Willow PRVD

RE: Willow P.R.U.D., Mitton and Lassell Streets

On October 29, 1996 the Portland Planning Board voted unanimously (5-0; Krichels, Decourcey absent) on the following motions regarding the Willow P.R.U.D. subdivision and site plan:

**TO:** Sarah Hopkins, Senior Planner  
**FROM:** Steve Bushey, Development Review Coordinator   
**DATE:** October 21, 1996  
**RE:** Fore River Place Subdivision Review Letter #5

**Drainage & Erosion Control**

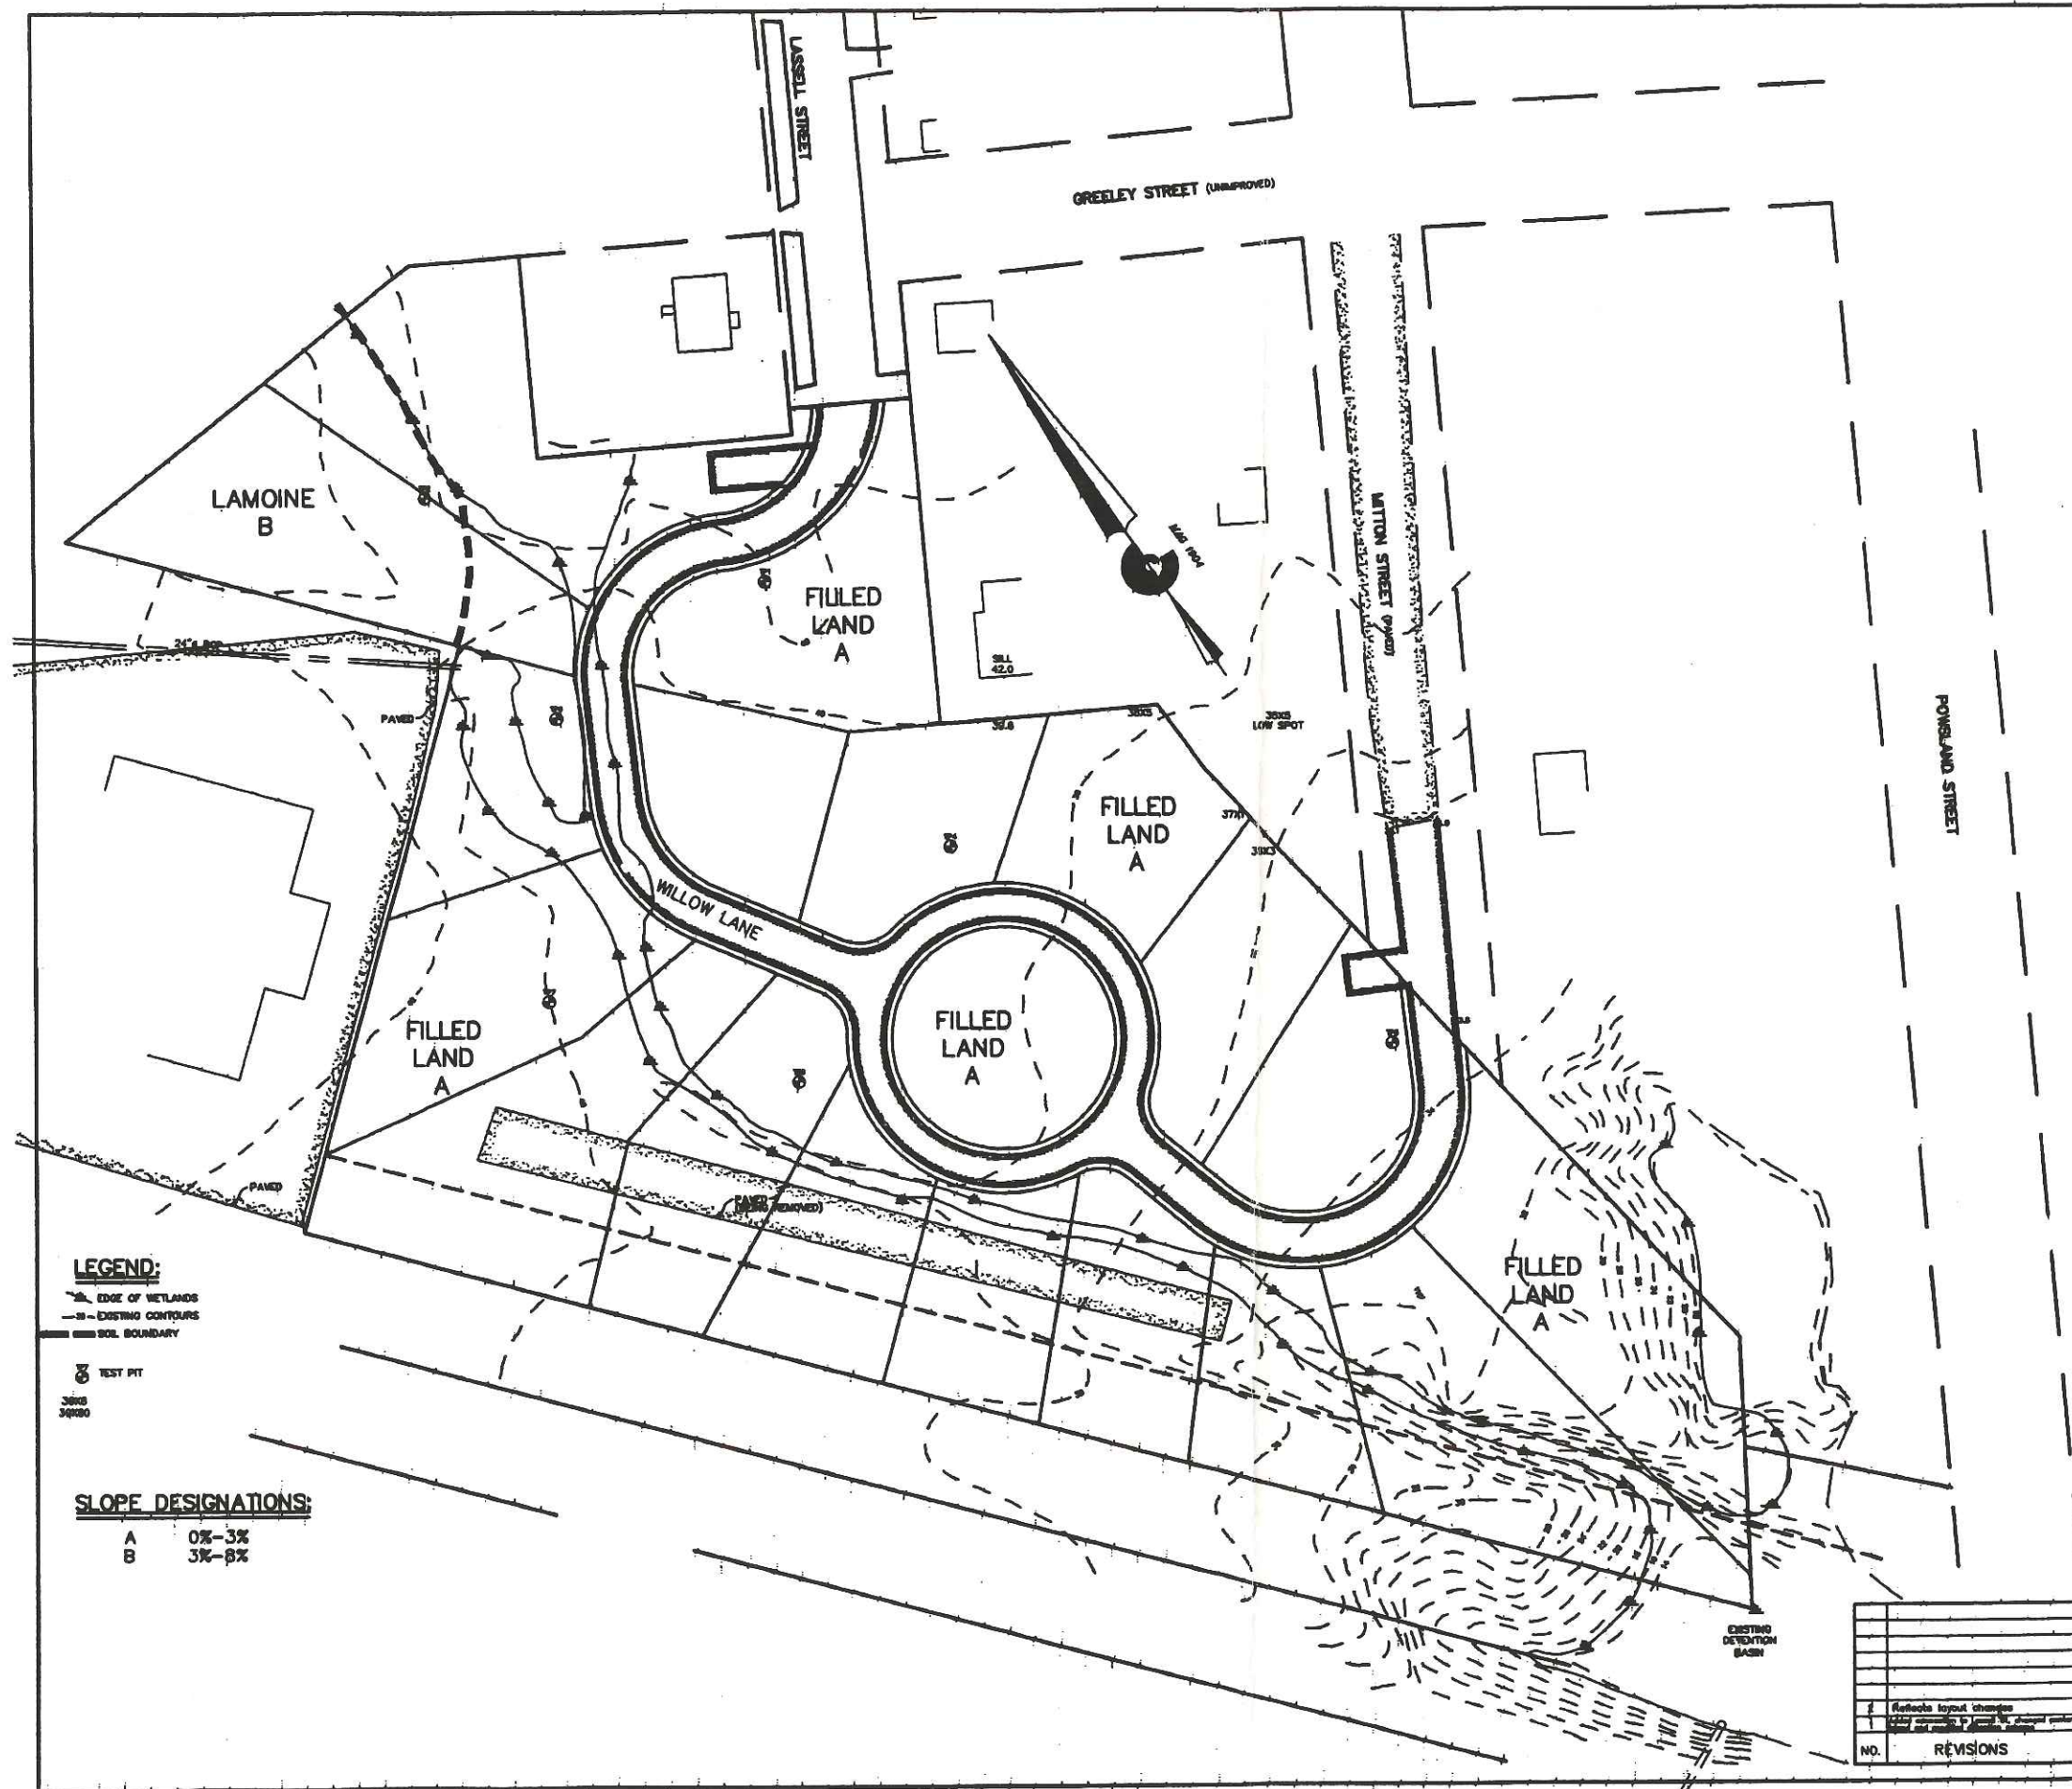
- OK iv. That the applicant should revise the grading plan to include a specific grading design behind lots 2 and 3 that will ensure drainage to CB#1 and not ponding on the neighboring property.

- ok 6. The plans should contain a detail for the installation of CB#5. The top of the existing 24" RCP entering the structure will be less than 6" below the rim elevation. How will this be constructed?

- ok 7. The CB#3 rim elevation is proposed as 38.0; this will be two feet lower than the surrounding proposed contours shown on the plan. The applicant should provide details for this area. Rip rap stabilization will be required for any area greater than a 3:1 slope.

- ? - 10. The stone inlets into the onsite pond areas should have a depth of stone equal to 8".
- ok 11. Two CB#5's are identified on the drainage plan. It is assumed that the CB at road sta 6+88 is actually CB#6. Haybale inlet protection should be identified on all CB's.

- ? - 12. The construction sequence on sheet 4 of 5 "Drainage and Erosion Control" plan states in Step 7 and Step 9 that base and surface pavement will be installed. This does not agree with the typical roadway section. The applicant should clarify.

- ok 13. The Maine Erosion and Sediment Control Handbook for construction BMP requires the rip rap swale minimum depth of rip rap to be 1.5 times the maximum stone size, therefore the depth shown in the detail on sheet 4 should be 24" instead of 18".

**Lot Configuration Plan**  
**Fore River Place**  
Lassell & Mitton Streets  
Owner/Developer  
NEPTUNE PROPERTIES  
120 Exchange Street  
Portland, Maine 04101

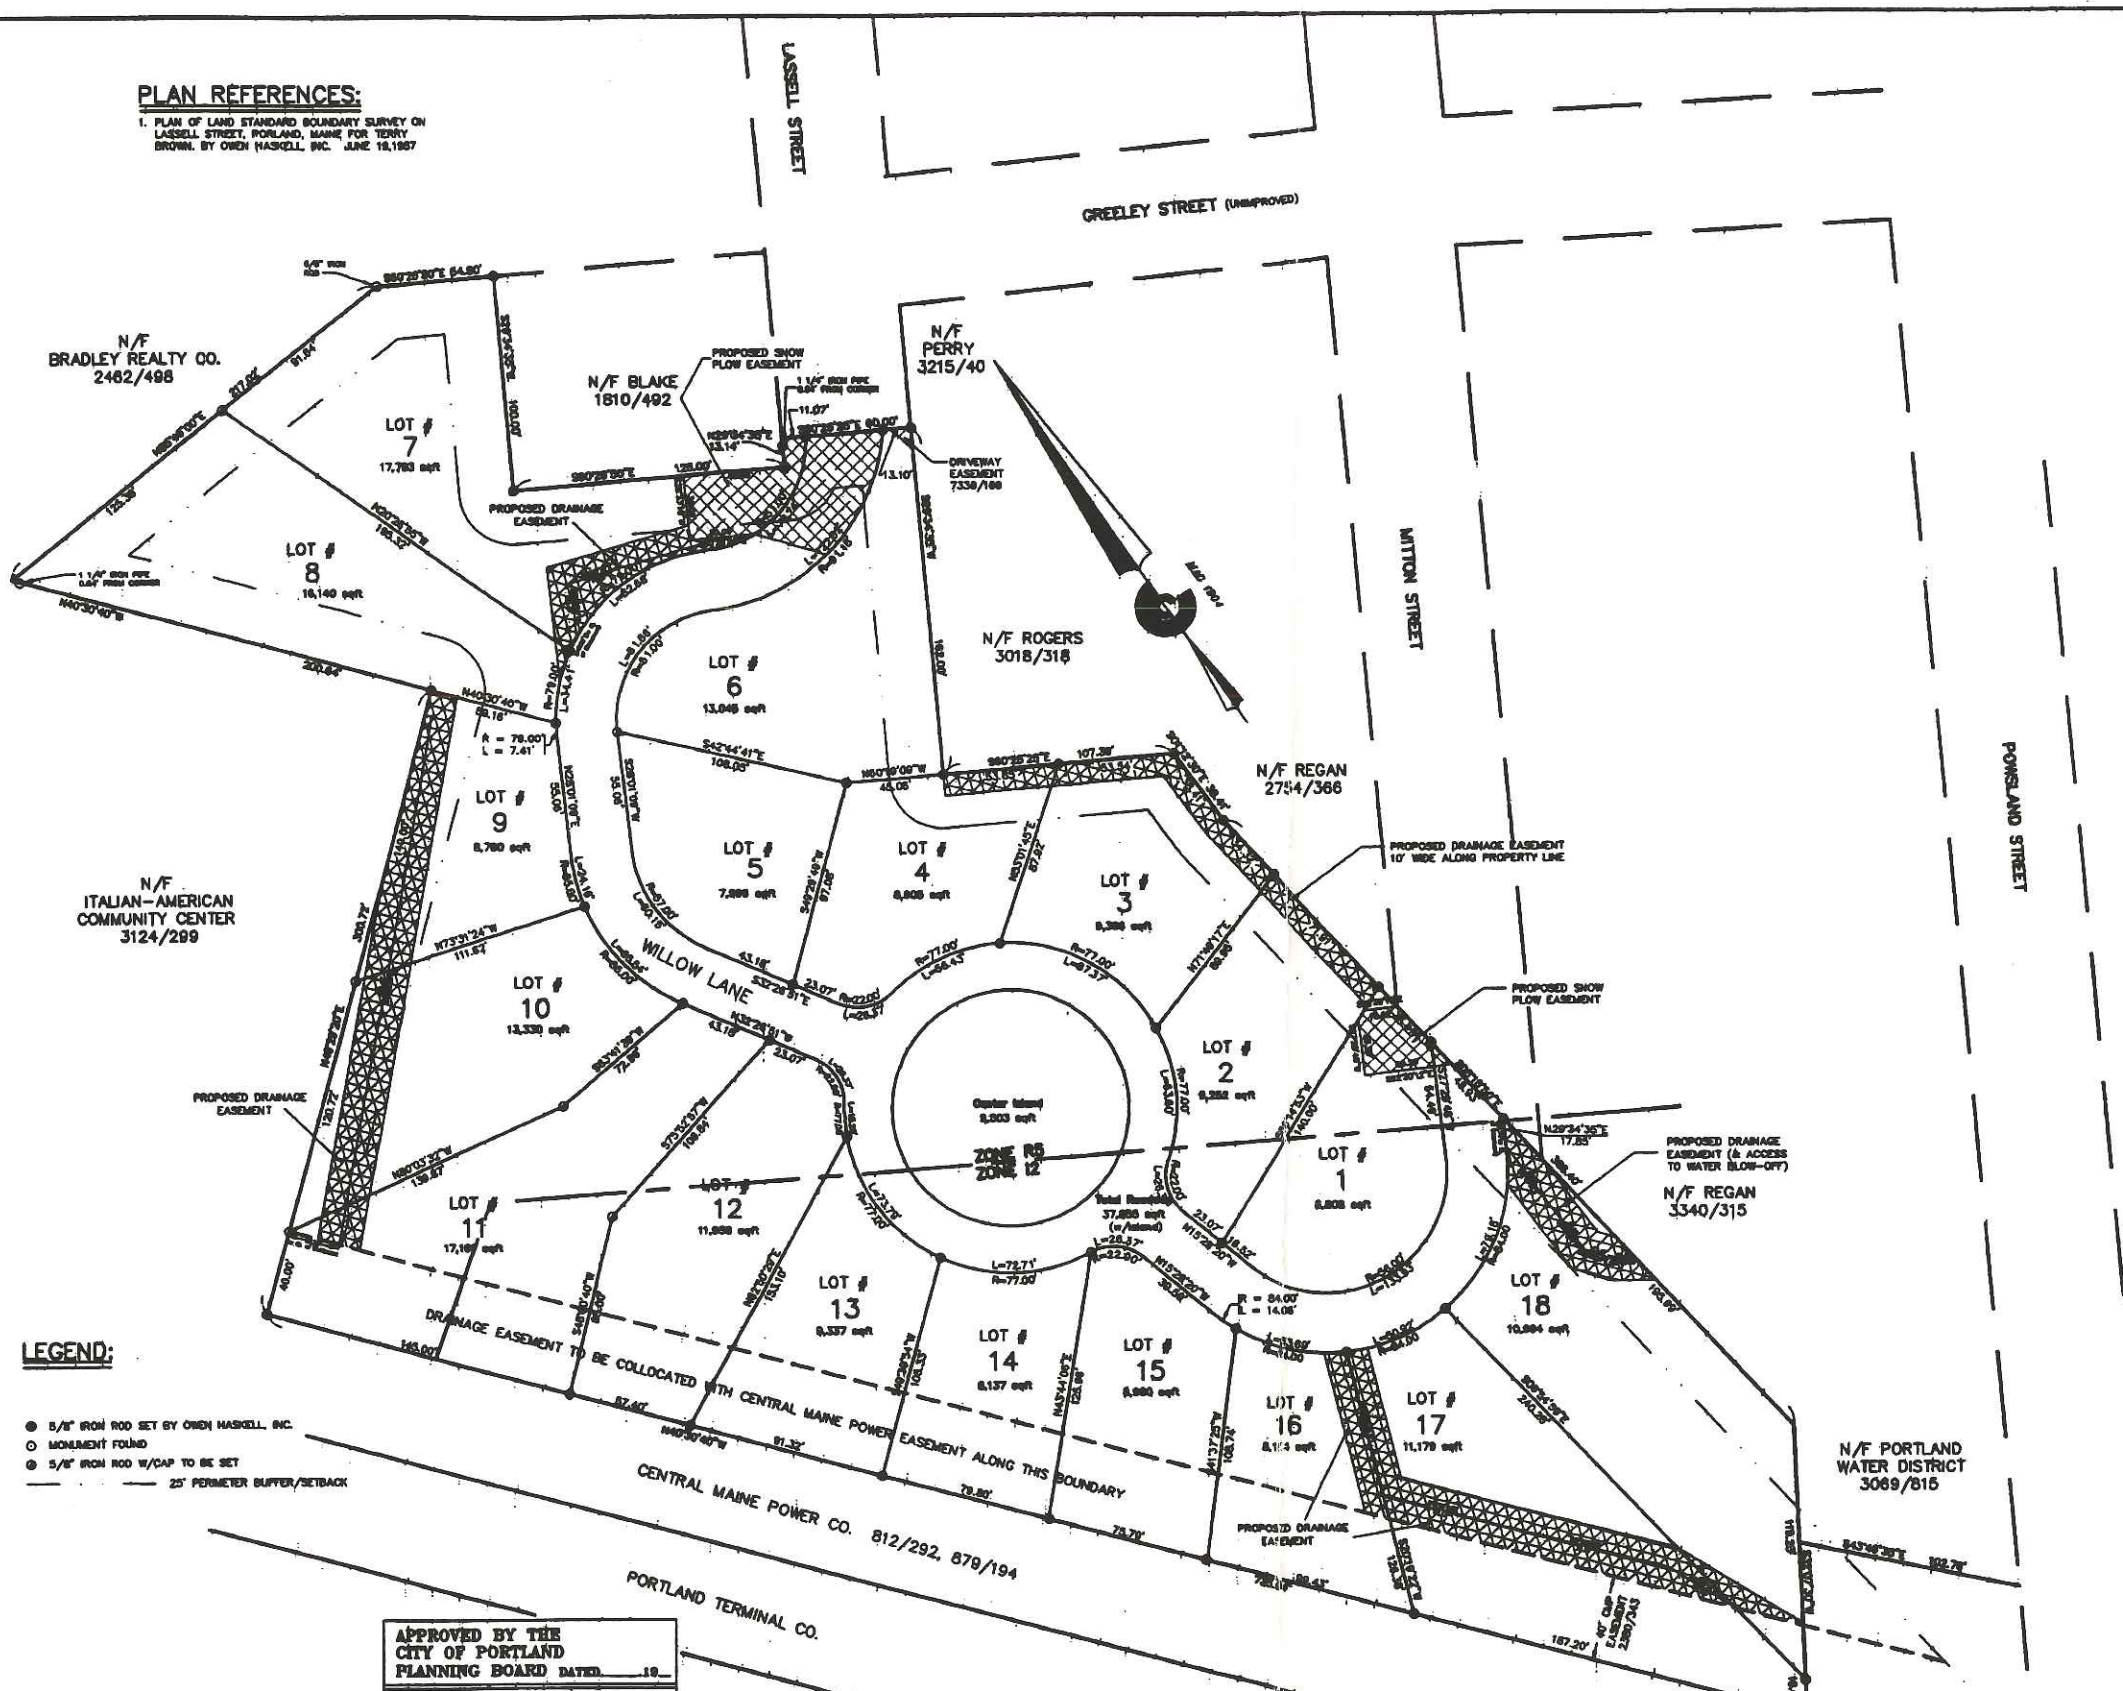
- ok 1. The lot configuration Plan should be signed by the licensed land surveyor who stamped the plan prior to signature by the planning if the plan is approved.

- ok 2. As discussed with Tony Lombardo of the Public Works Department, a snow plow easement should be provided along the lot 6 frontage in order to allow snowplows adequate area to turn around. Public Works should provide exact dimensions for the area.
